Boston Alternative Energy Facility

**Natural England's Comments on Without Prejudice Habitats Regulations Assessment
Derogation Case: Compensation Measures [REP8-006]**

Planning Inspectorate Reference: EN010095

24th March 2022

**Table 3-1 Summary of without prejudice impacts and affected areas and numbers of birds.**

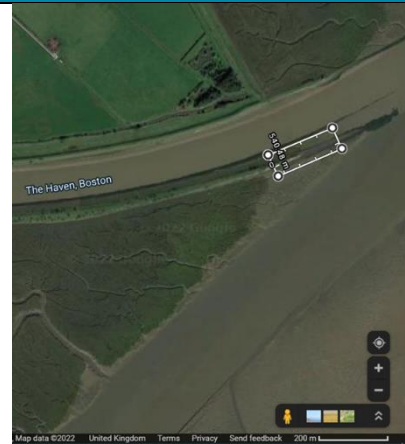
3.	Table 3.1	NE queries if map images of the two missing locations i.e., between the Habitat Mitigation Area to the SPA boundary & SPA boundary to HMP North Sea Camp could be added for consistency?
